From: Sarah Fawdry [REDACTED]
Sent: 02 March 2023 15:55
To: Jessica Riches; David Easton
Cc: Chris Brake; Katie Martin; Martin Kempshall; Thomas Richards; Silvie Steiningerova
Subject: Bilsham Road, Yapton - Y/70/22/DOC and Y/34/22/DOC
Attachments: 2023 02 08 Y 70 22 DOC Drainage Response.pdf; D1956-13-200B Proposed Levels Layout.pdf; D1956-13-201B Proposed Levels Layout.pdf; D1956-13-202B Proposed Levels Layout.pdf; D1956-13-300B Proposed Permeable Paving Formation Levels.pdf; D1956-13-301B Proposed Permeable Paving Formation Levels.pdf; D1956-13-302B Proposed Permeable Paving Formation Levels.pdf

Having recently picked up comments on your online portal regarding Y/70/22/DOC (dated 8 February 2023; attached for ease), please find our responses to the outstanding queries as follows. For ease and completeness, I have followed on from the previous queries with our responses, our latest response is detailed in green.

Drawing Status	CONSTRUCTION			
Client	THAKEHAM			
Project	BILSHAM ROAD YAPTON			
Drawing title	PRIVATE DRAINAGE DETAILS			
Scale	NTS	Date FEB 22	Drawn By	Checked By
Drawing No.	D1956-15-3		Rev.	B

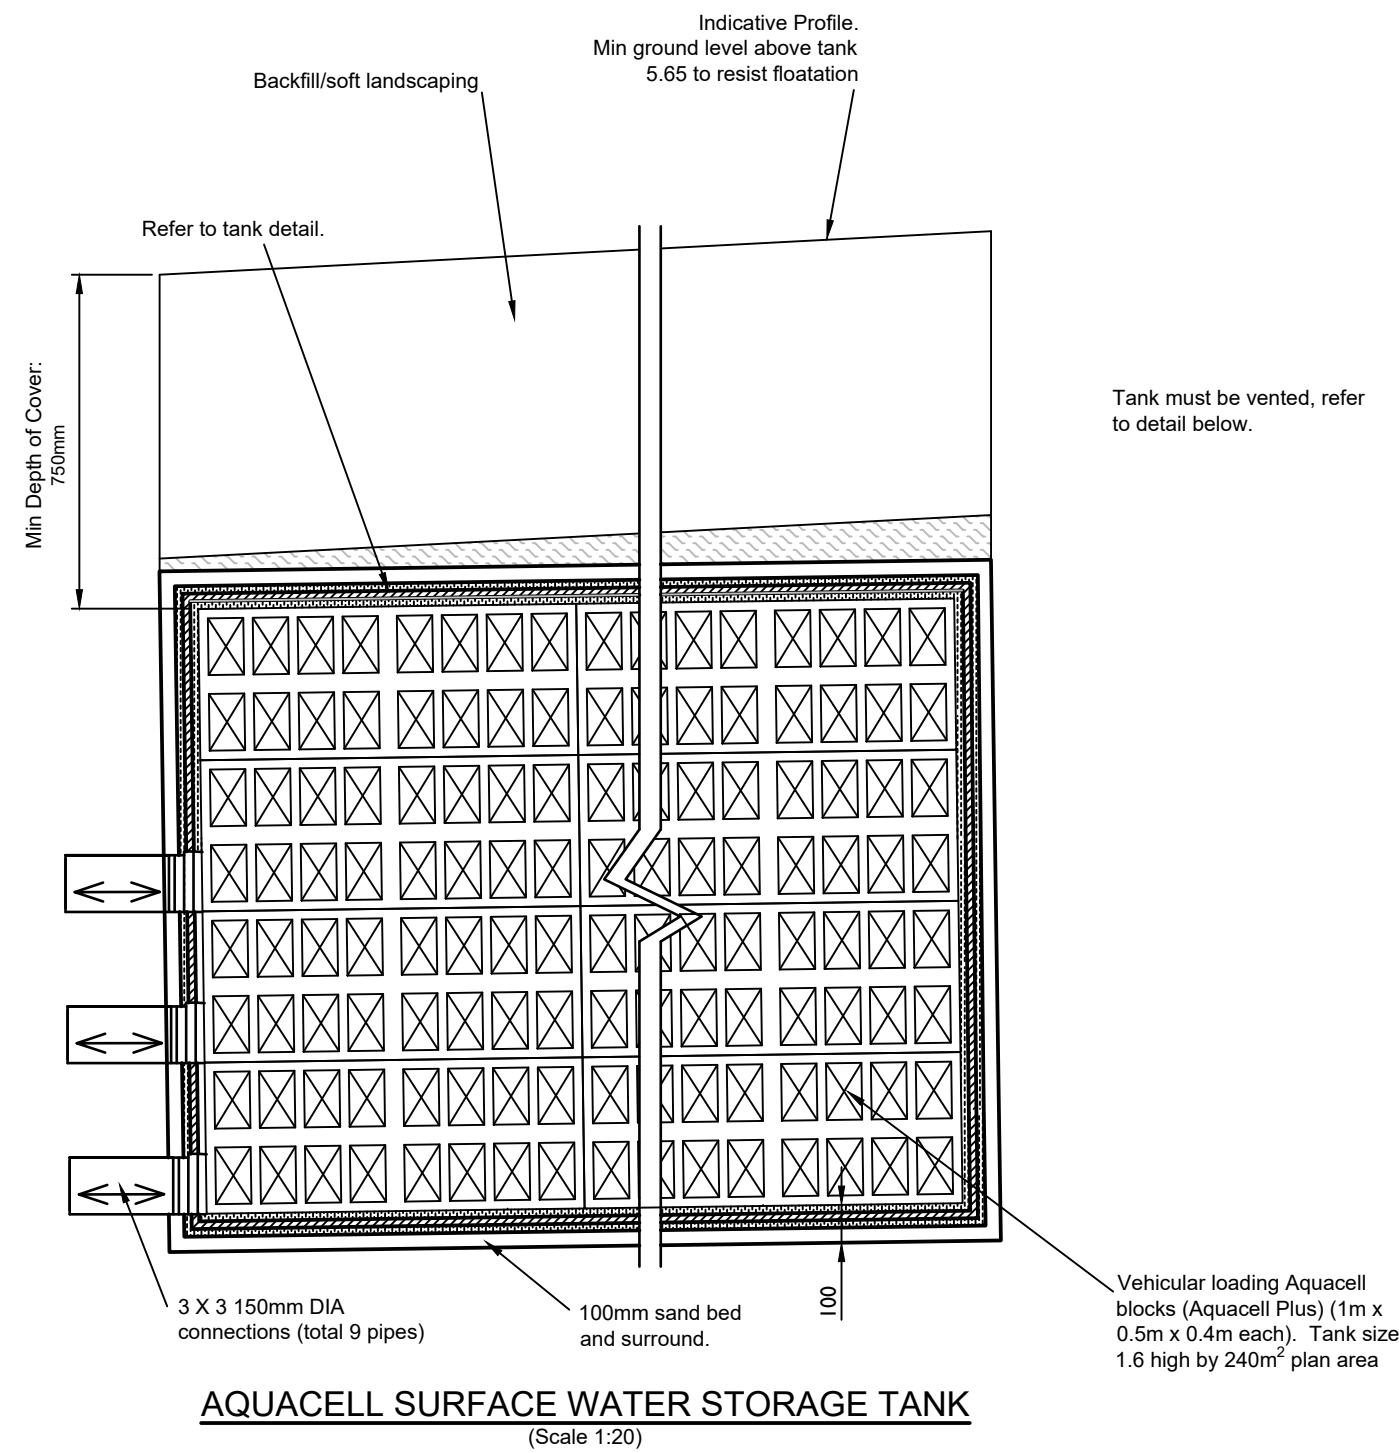
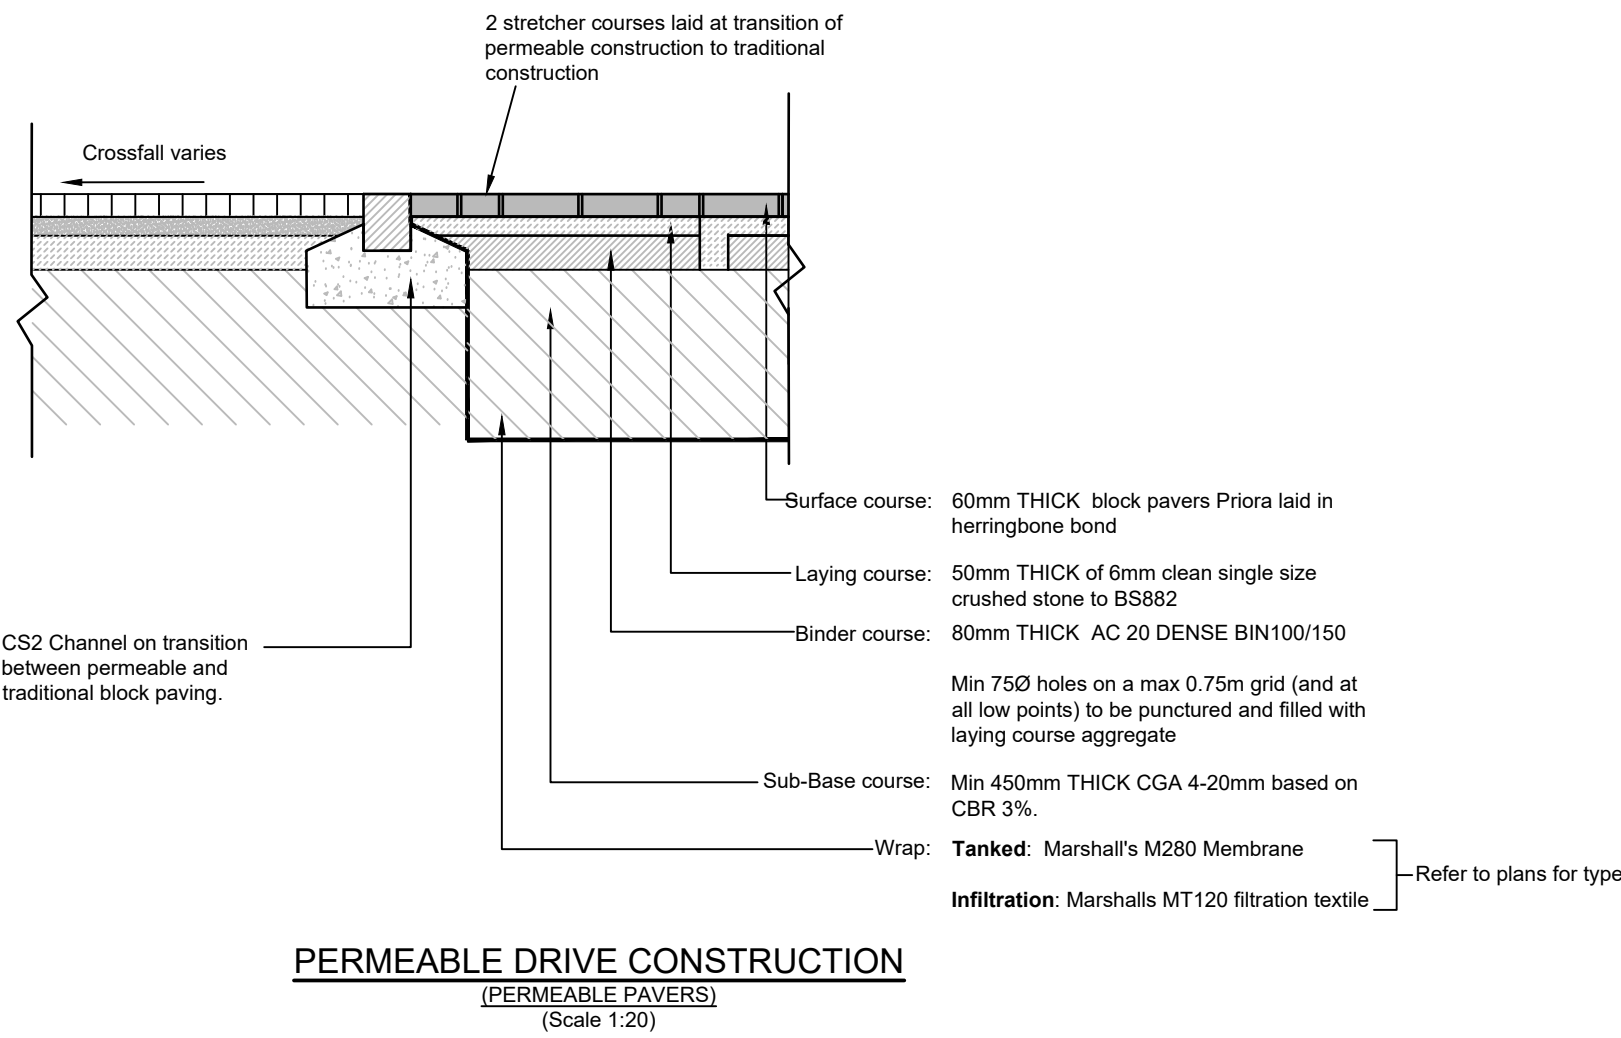
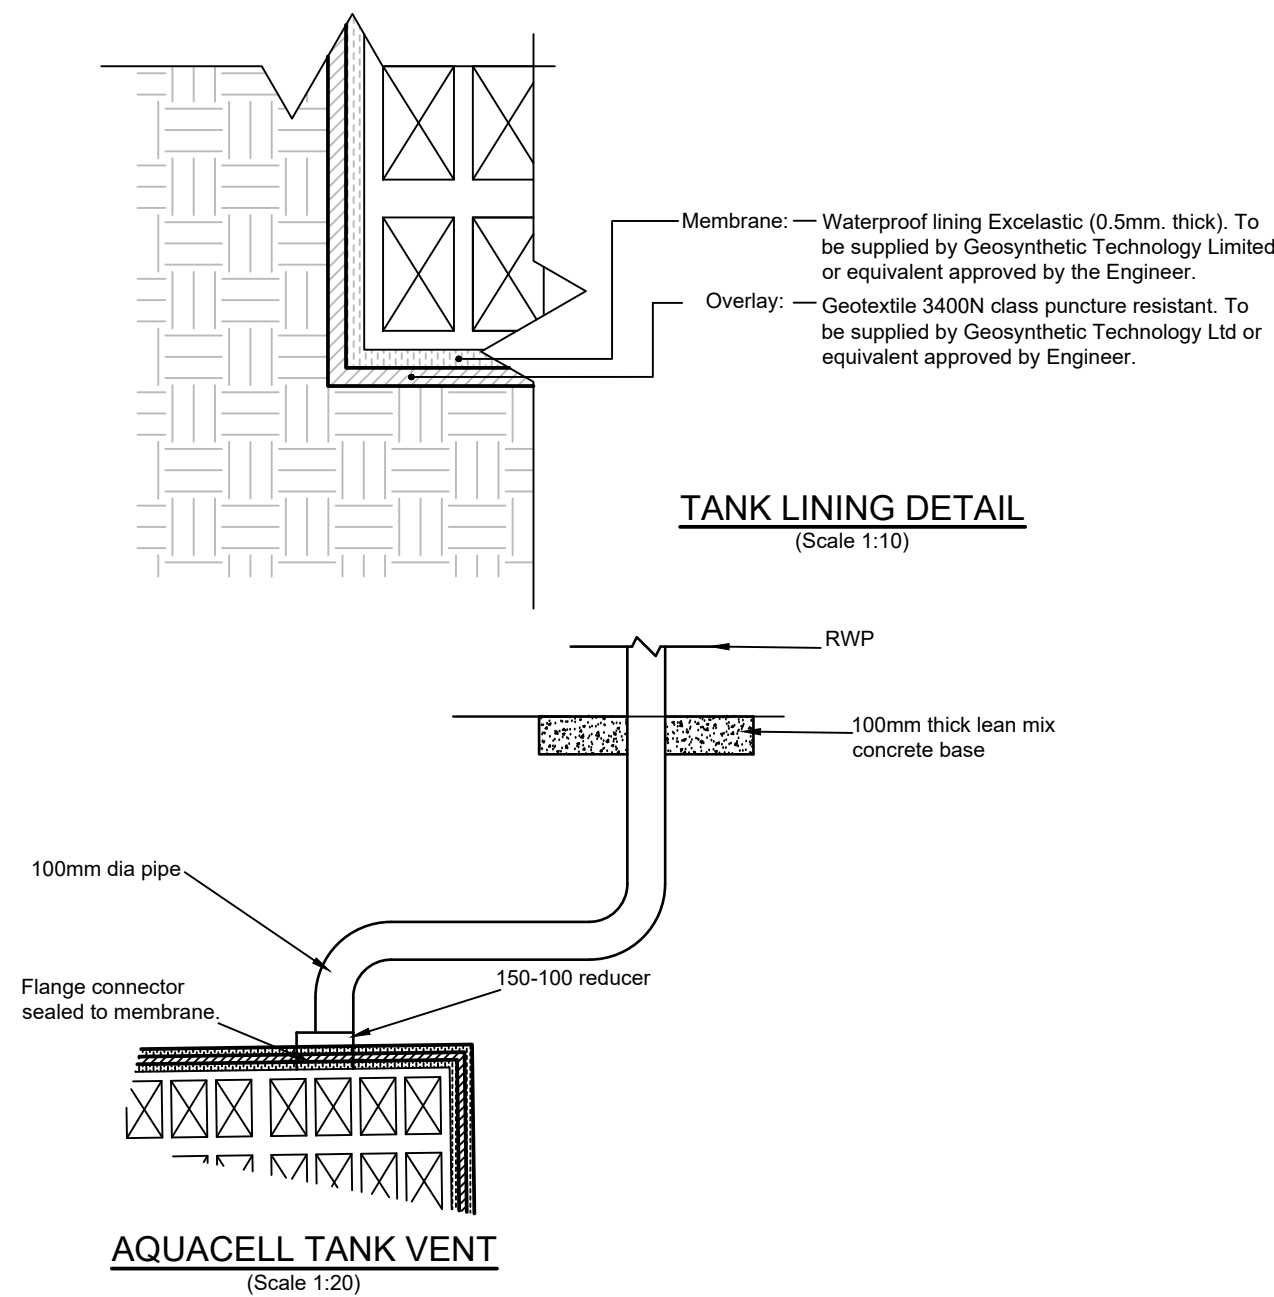
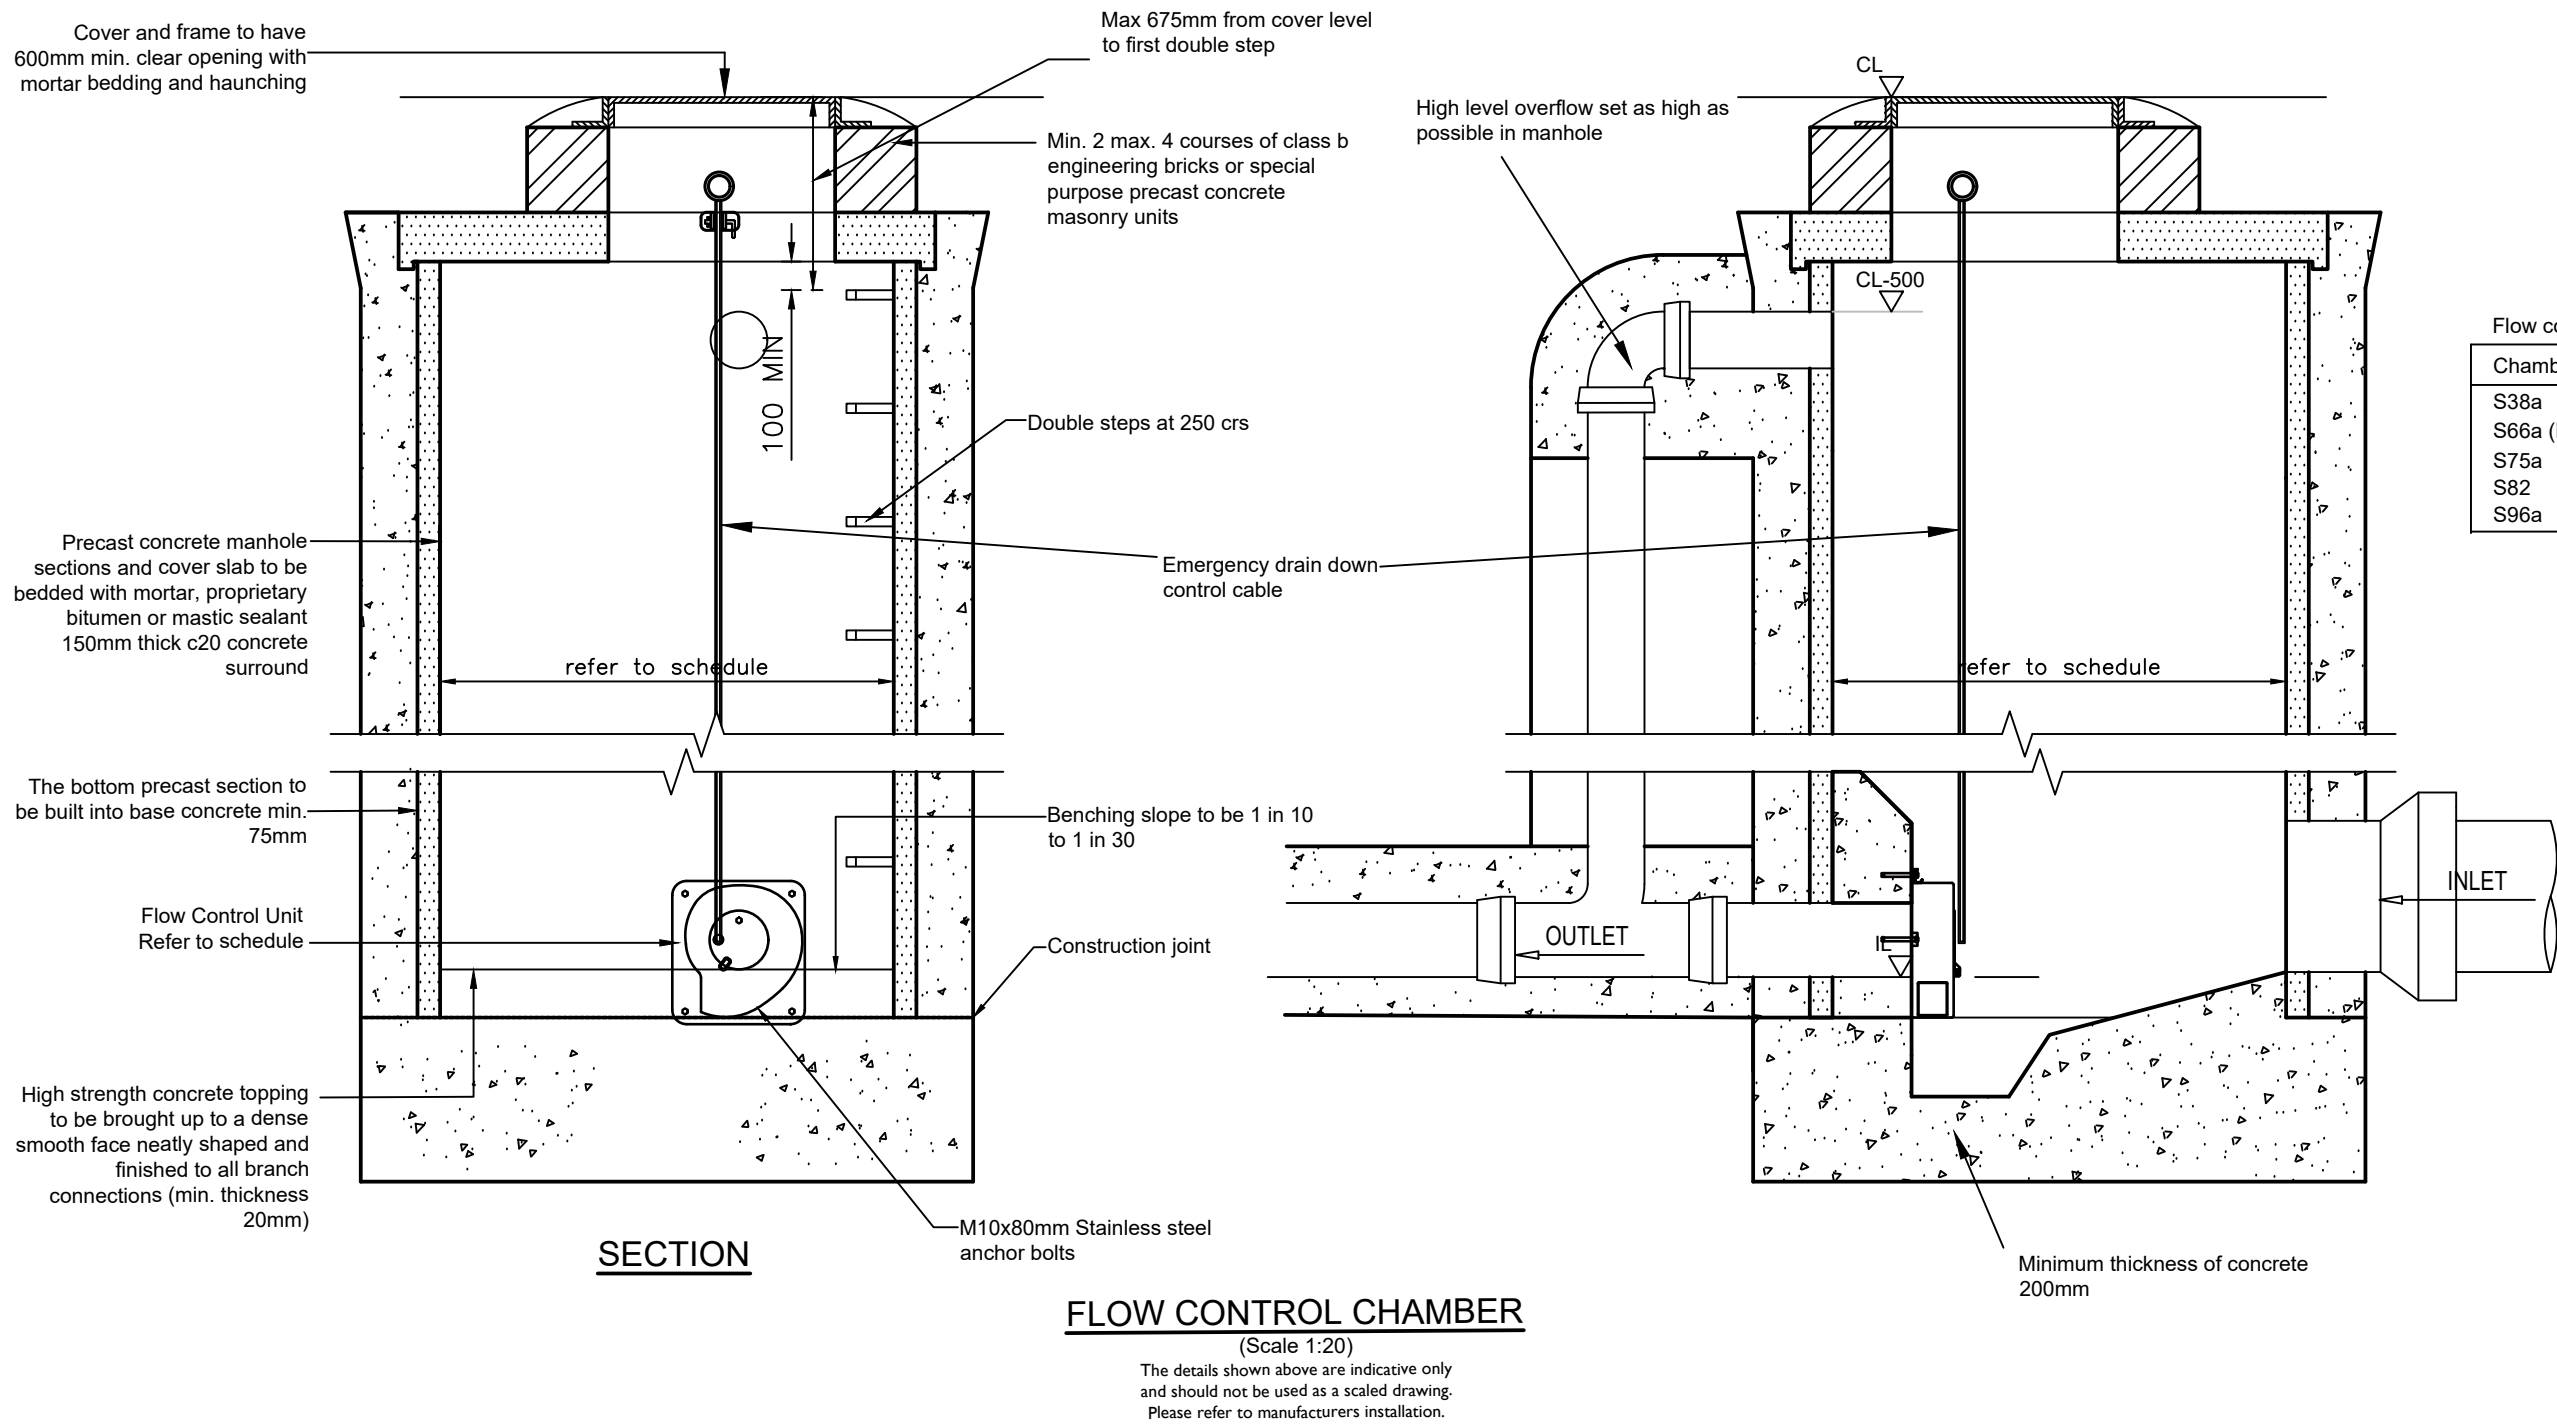
16. *Please provide a construction detail of permeable paving which clearly defines the construction, i.e. blocks, bedding, membranes, sub-base, tanking membrane. Materials and depths should be clearly defined. The construction detail shown on drawing D1956-15.2 conflicts with that shown on D1956-15-3A. These need to be updated to ensure there is no conflicting information. In addition to this its not clear why part infiltration has not been sought in areas where the infiltration has demonstrated that this is achievable. The applicant should clarify clear reasons as to why infiltration techniques have not been used for the permeable paving in the areas within the vicinity of the following test locations: TP05; TP04; TP01. 08/2/2023- This has now been received and we have no further comments. TH: RESOLVED No further action required*
